Harnett County

Permit Number: BCOM2503-0003

Description: **Construct a 60 x 80 Multi Purpose Bldg Harmony Baptist Chur**

LIST OF REVIEWS

**NEW FELLOWSHIP HALL
AND PUMP STATION**

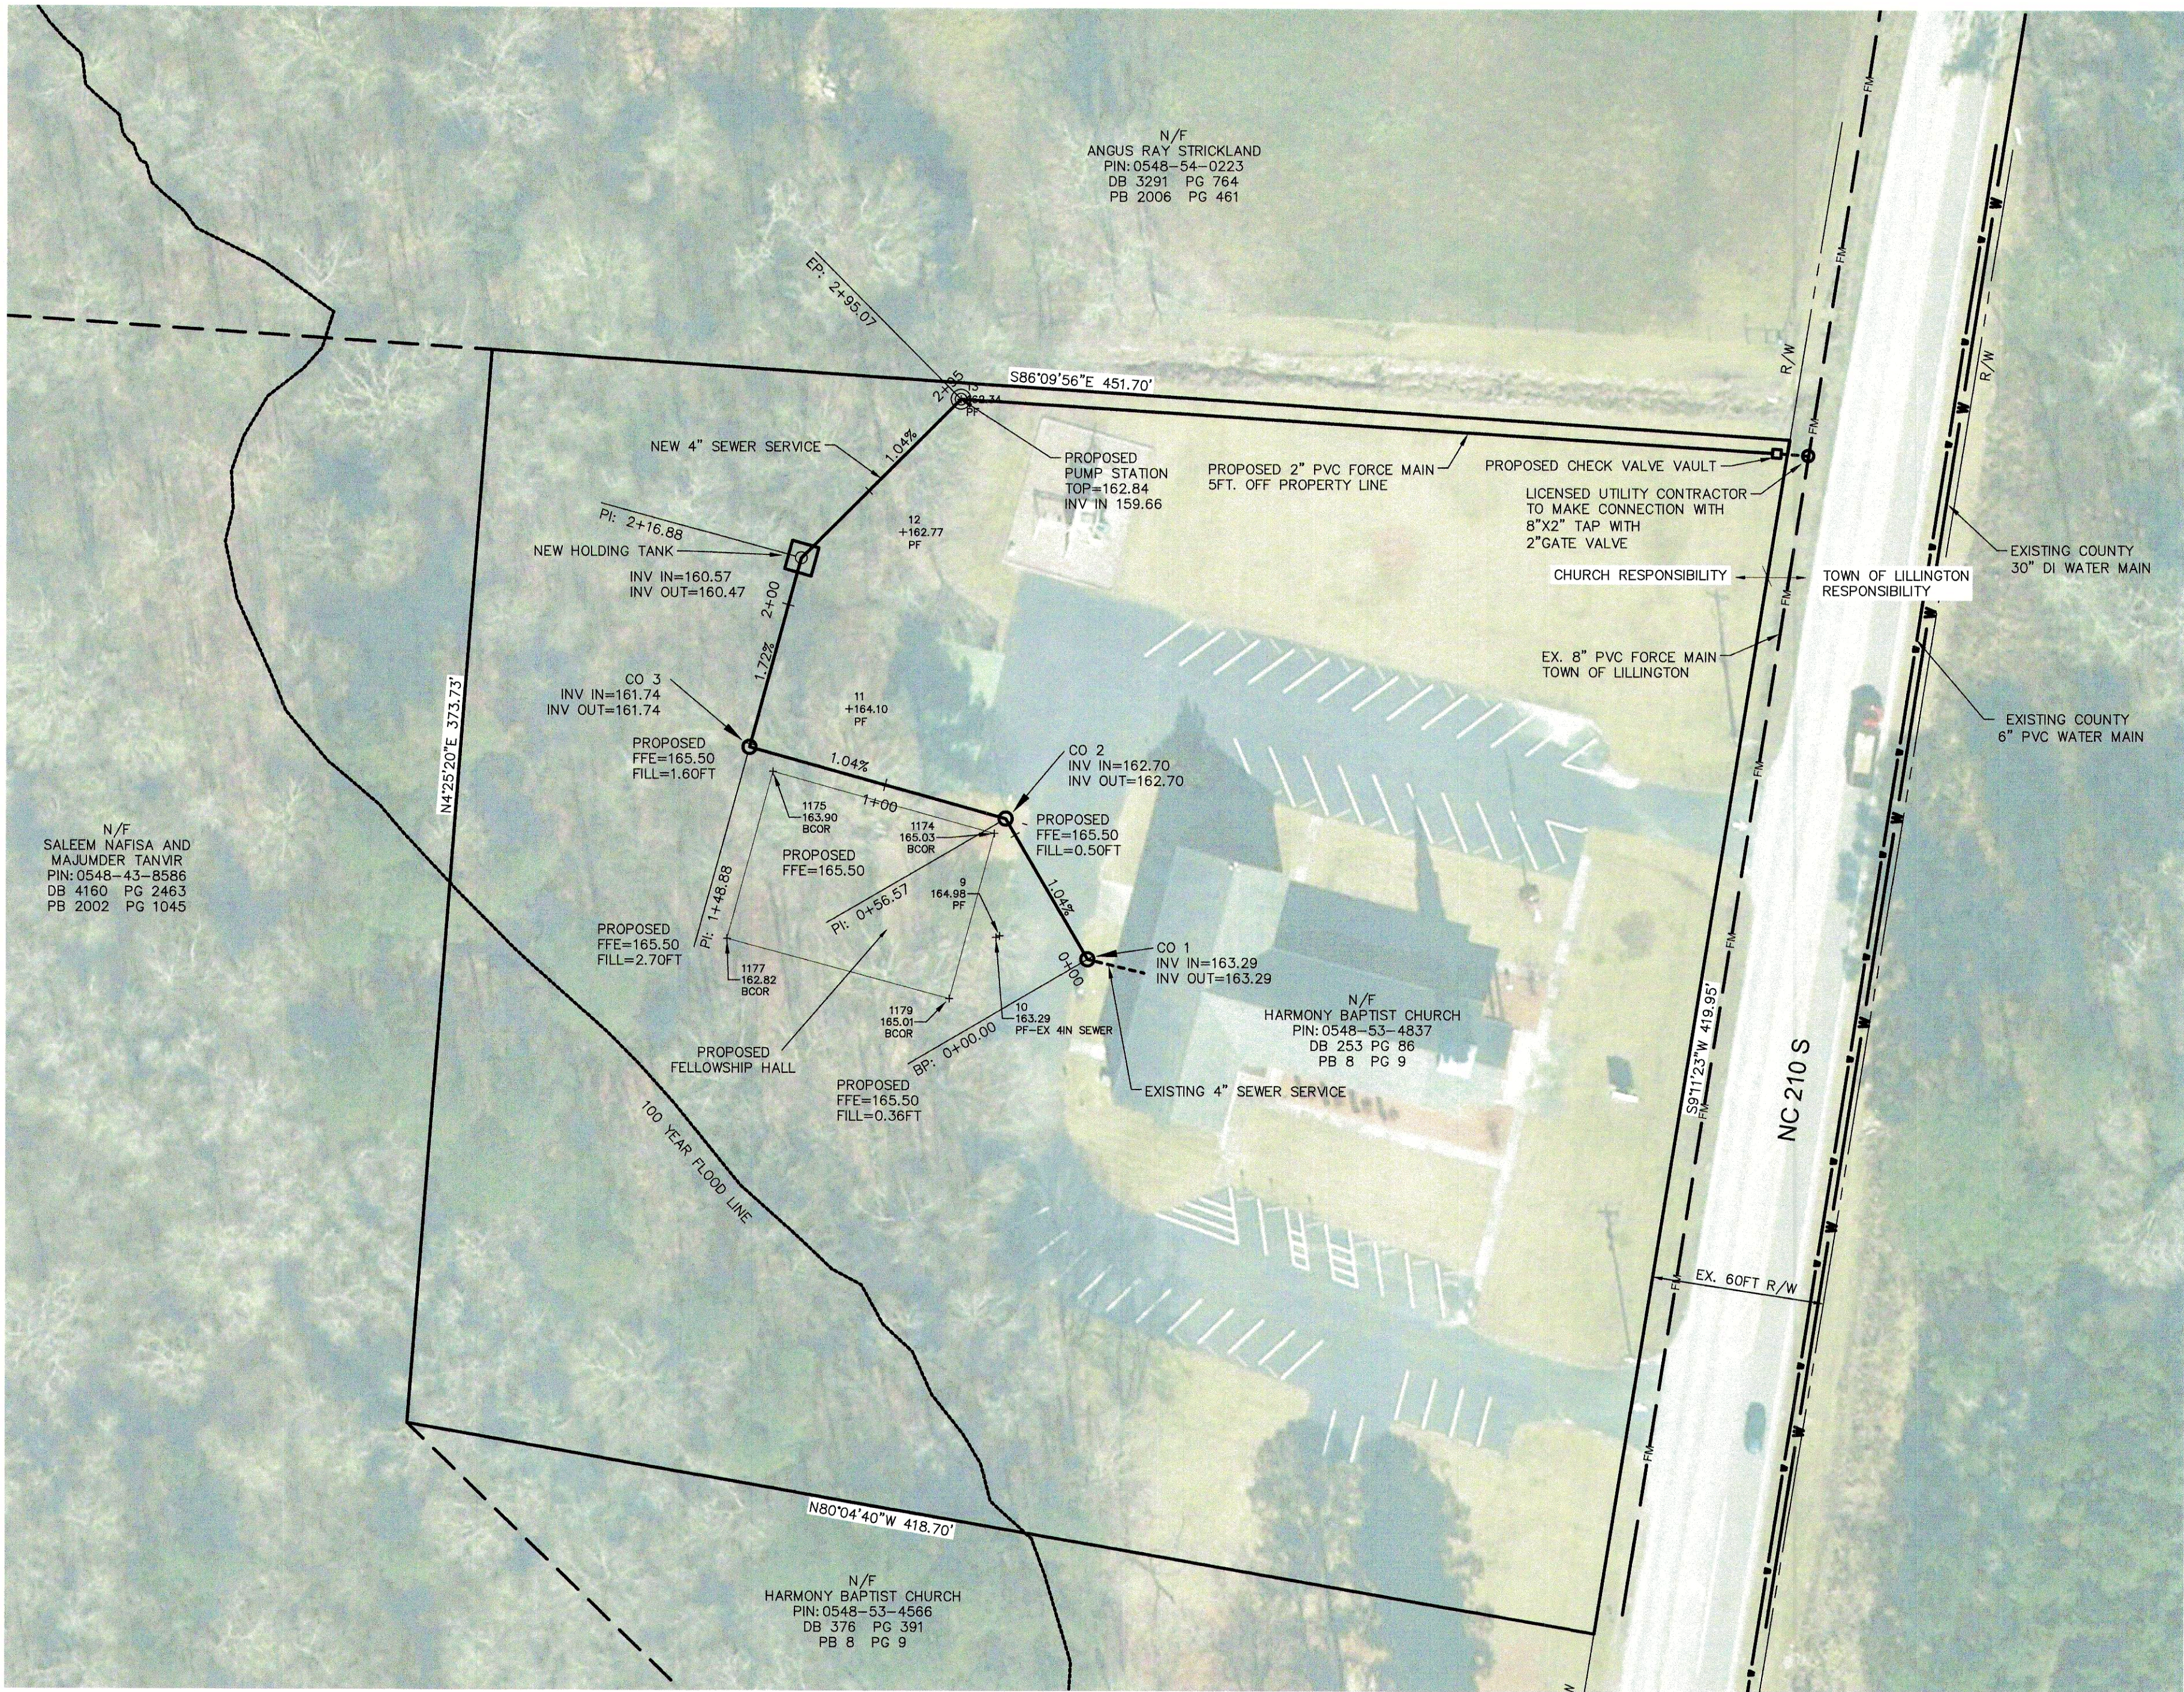
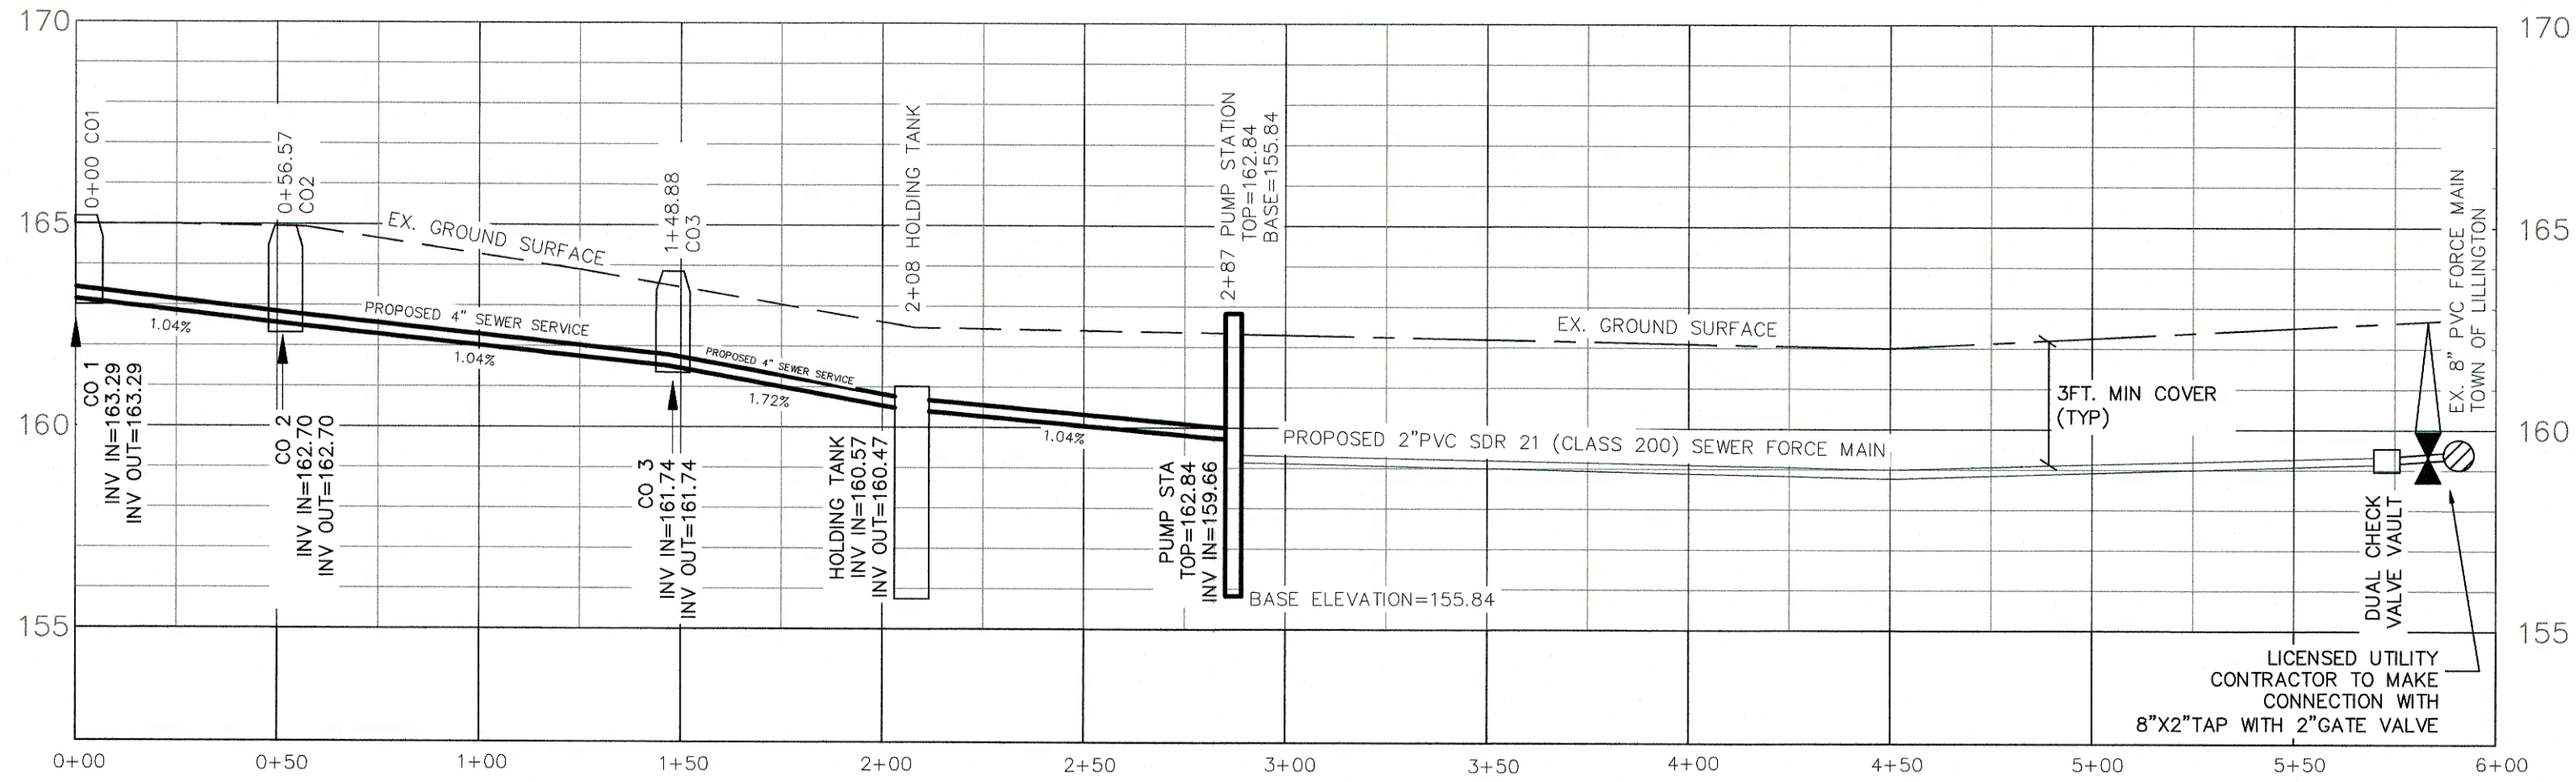
Notes:
 - need updated site plan showing setbacks & FEMA 100 yr fp
 - if new structure is within the 100 yr fp, an Elevation Cert will be required prior to issuing bldg permits
 - LUP2504-0003 site plan = \$100 review fee

Notes:
 revised site plan is OK
